City of  
Canada Bay

Our Ref: DA: 342/2010 & MP 10\_0058  
Date: 31 August 2010

**Subject: Request for Further Information**  
**Property: Part 3A Project Application for 52 - 58 Walker Street RHODES**

**Application No.:** 342/2010  
**Property:** LOTS 101 AND 102, and part of 107 in DP 1134195  
52 Walker Street, Rhodes NSW

**Figure 7a: Recommended *Minimum* Tree Planting Layout for the Ground Level**

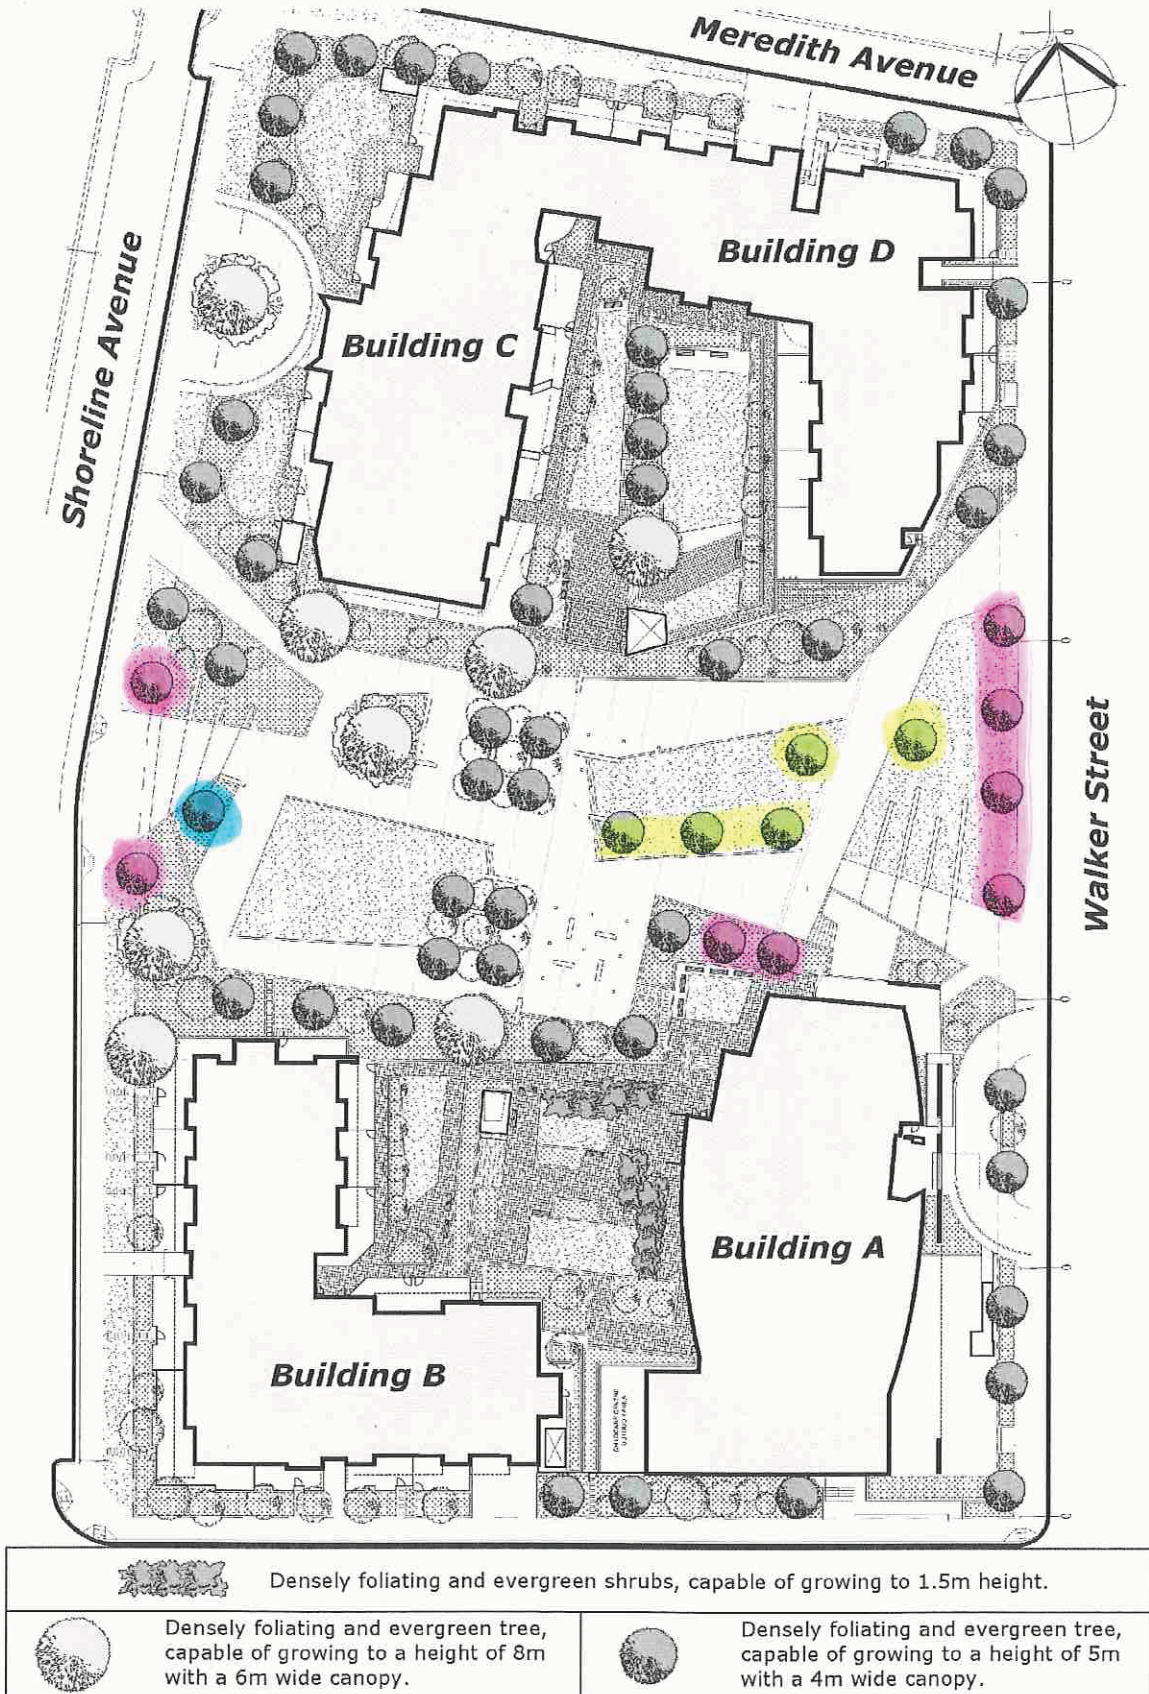
The proposal meets the numerical deep soil provision as per the Draft DCP and far exceeds that of the Residential Flat Design Code. However, the Pedestrian Wind Environment Study, Appendix 12 suggests that a number of trees (density foliated and evergreen 5m and 8m high trees with 4m and - 6m wide canopies) are required for wind mitigation (see Figure 7a: Recommended Minimum Tree Planting Layout for Ground Level pg.35).

None of the DA or Landscape Plans show a provision of deep soil, planters or boxes to accommodate these trees beyond the deep soil area concentrated towards Shoreline Drive, which results in approximately 17 required trees and 2 shrubs as shown on the Pedestrian Wind Environment Study without a proper soil provision.

Required trees for wind mitigation need to be addressed and coordinated within the Landscape Plans.

- Proposed trees on the eastern part of the open space (Walker St) as suggested in the Pedestrian Wind Environment Study – appendix 12 would provide the necessary break for adverse winds created by the location of tower buildings. Please see, Environment Assessment Report- see Figure 7a: Recommended Minimum Tree Planting Layout for Ground Level p.35.

**SWEPT PATH ANALYSIS
OF A 10.2m REFUSE
VEHICLE EXITING THE SITE**

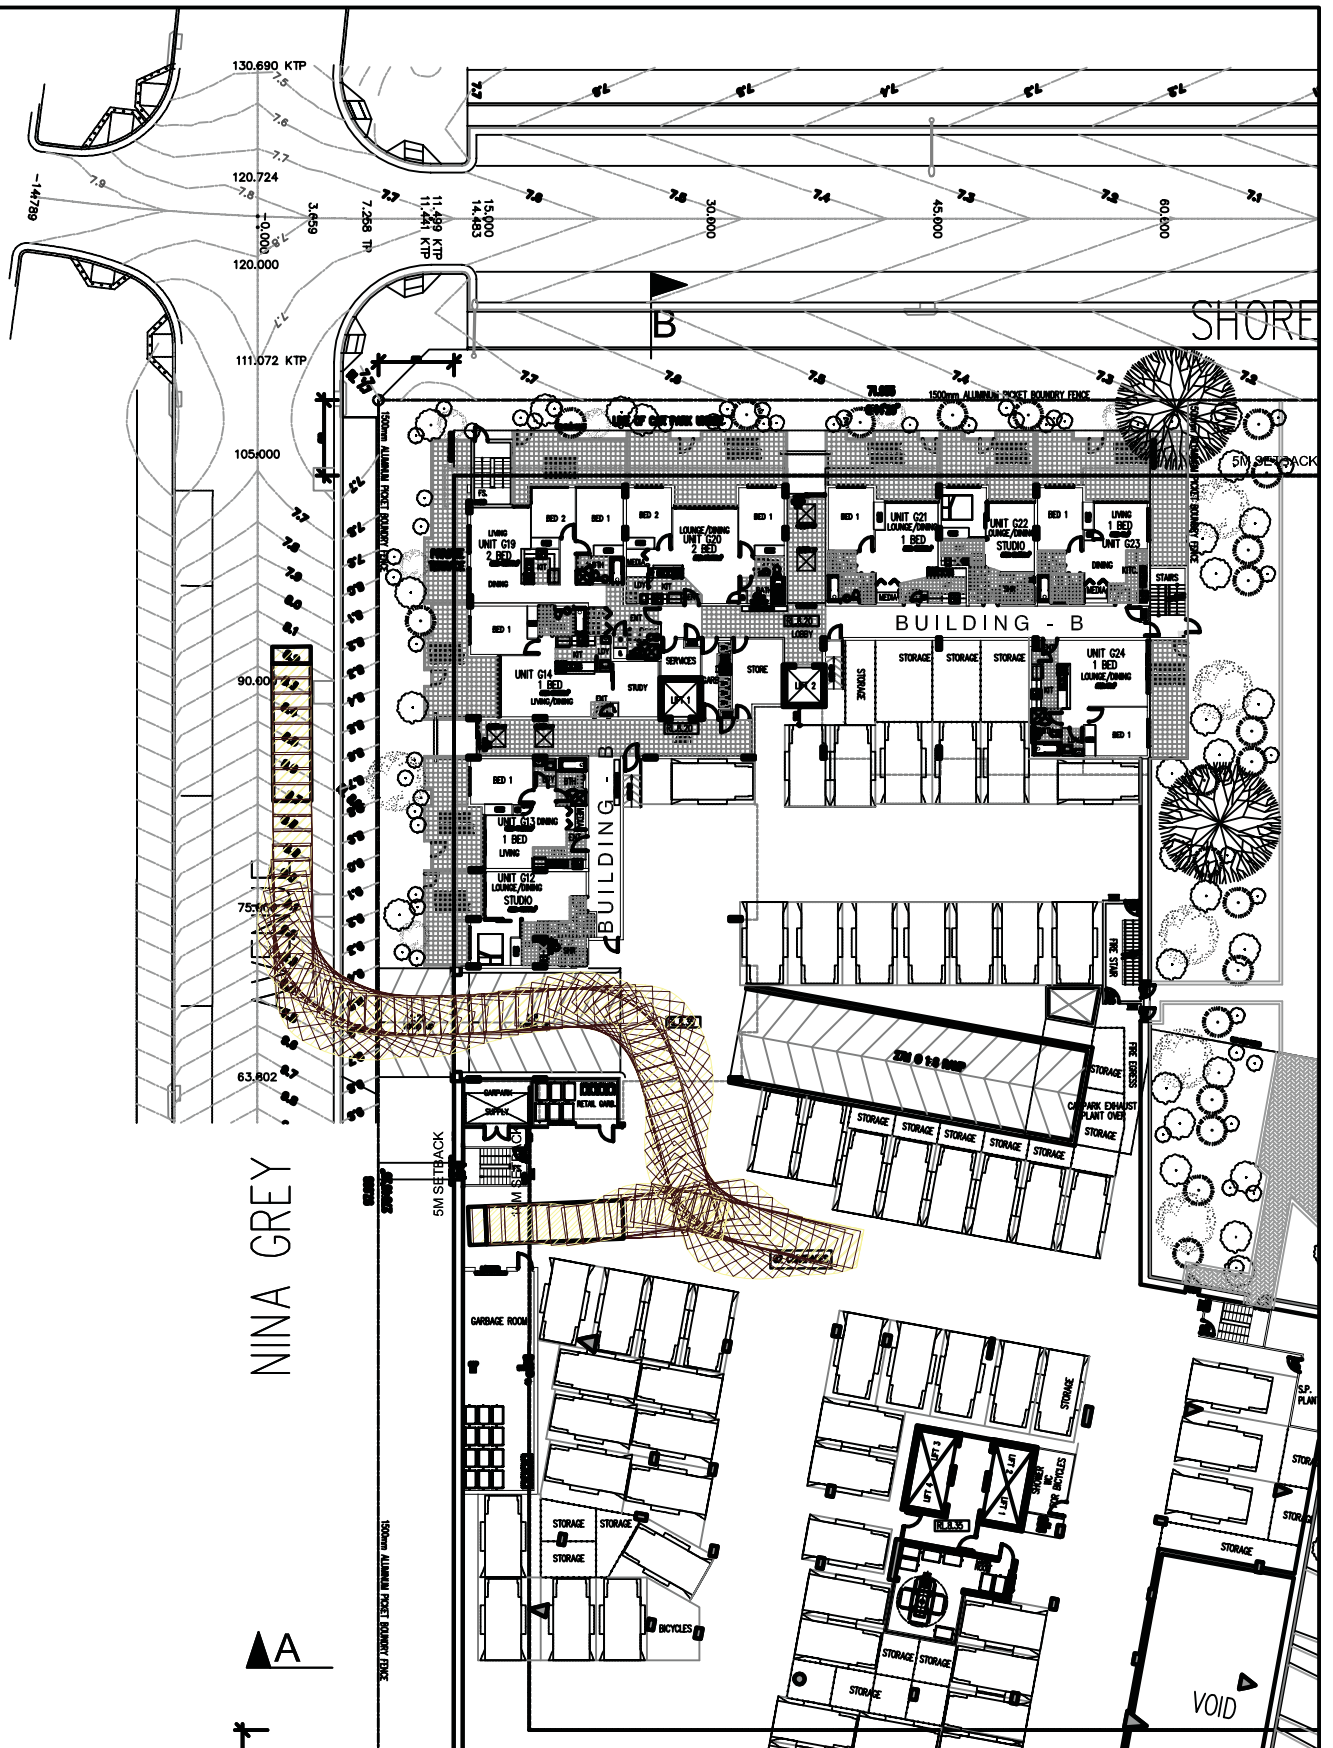
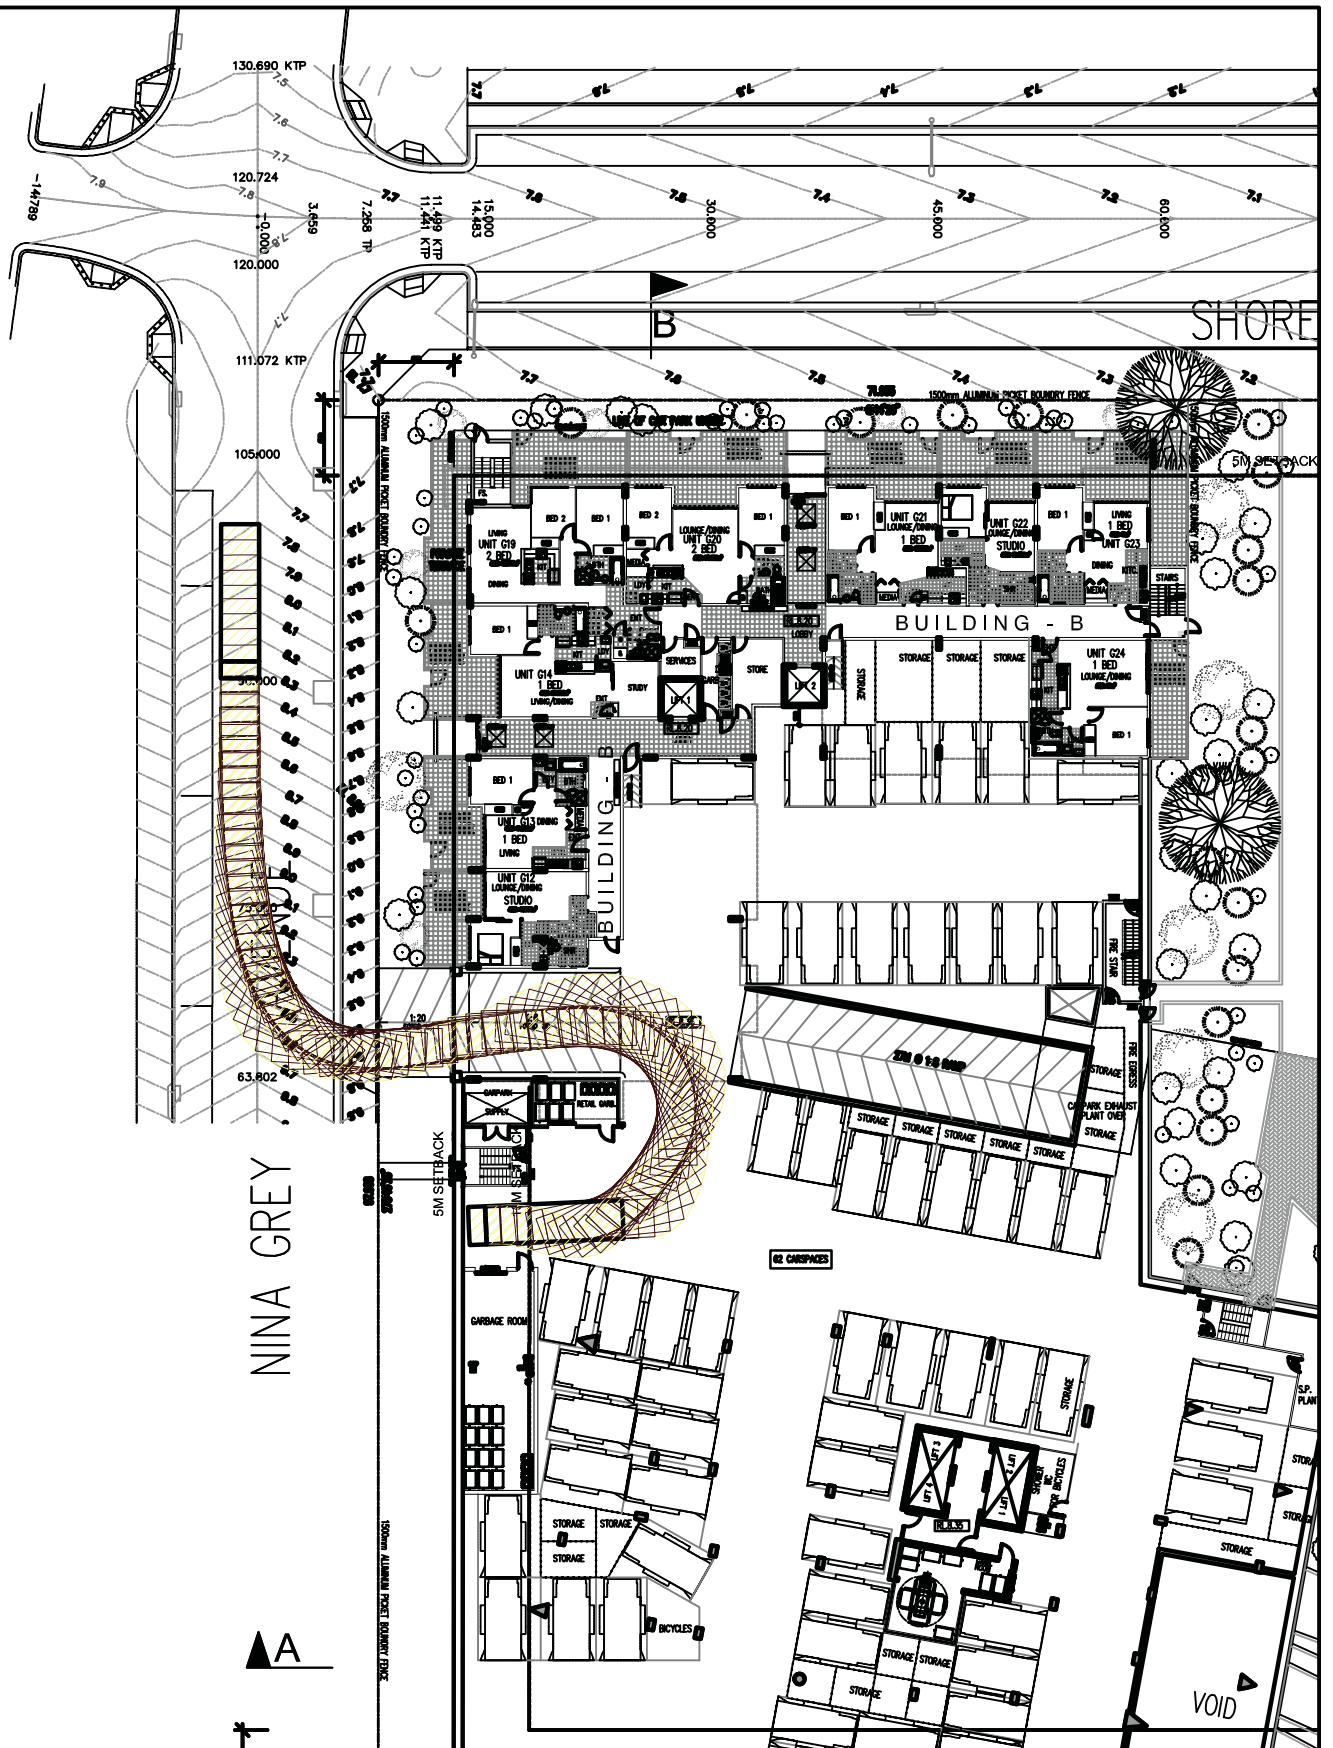
Officer are likely to affect the size of the proposed garbage store areas and that the available turning paths for garbage trucks and trolleys transferring garbage bins from the storerooms to the trucks appear to be inadequate. Concern is also raised about the proposed truck parking bay and garbage storeroom on Parking Level 3 accessed off Meredith Avenue and the void area over these spaces. It appears to be exposed to the levels of apartments above and may result in acoustic and visual privacy, and potential odour issues for the courtyard areas and balconies of apartments directly above these facilities. It is considered that this aspect of the design should be revisited.

PRELIMINARY
 LANDSCAPE PLAN
 Scale: 1:200 @ B1
 Drawing Number: 101 E

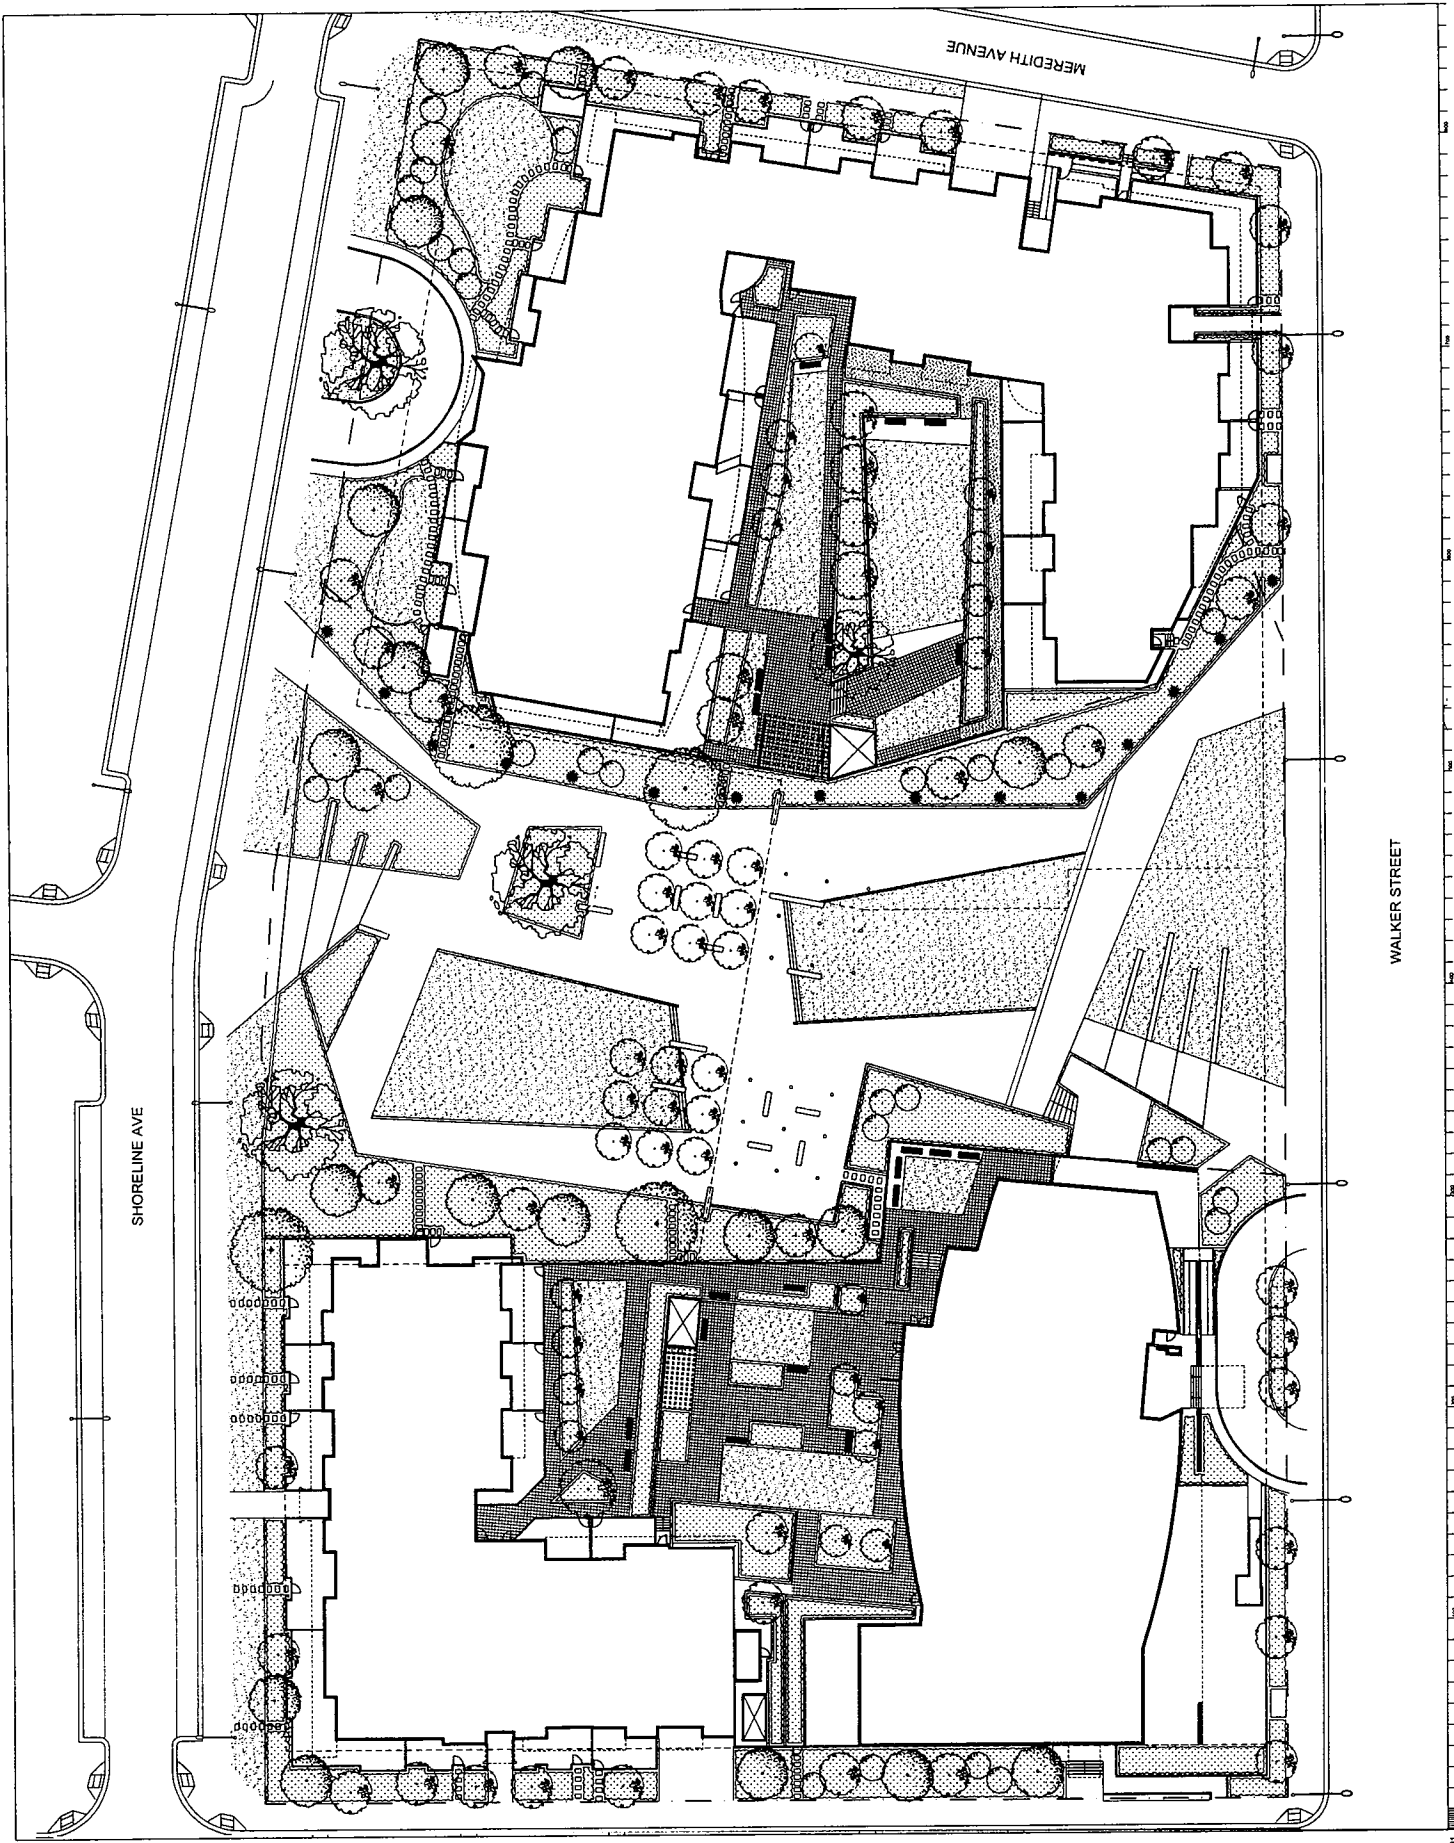
Council is concerned that a fully detailed Landscape Plan prepared a qualified Landscape Architect has not been submitted with the Part 3A Project Application that fully addresses all of the matters included in Point 3 - *Public Domain/Open Space and Accessibility* of the Director-General's Requirements. The Landscape Plan submitted does not fully detail deep soil planting areas, all plant species and numbers proposed, full details of seating and other outdoor furniture, lighting, pathway materials etc. Please also refer to GMU's comments in this regard.
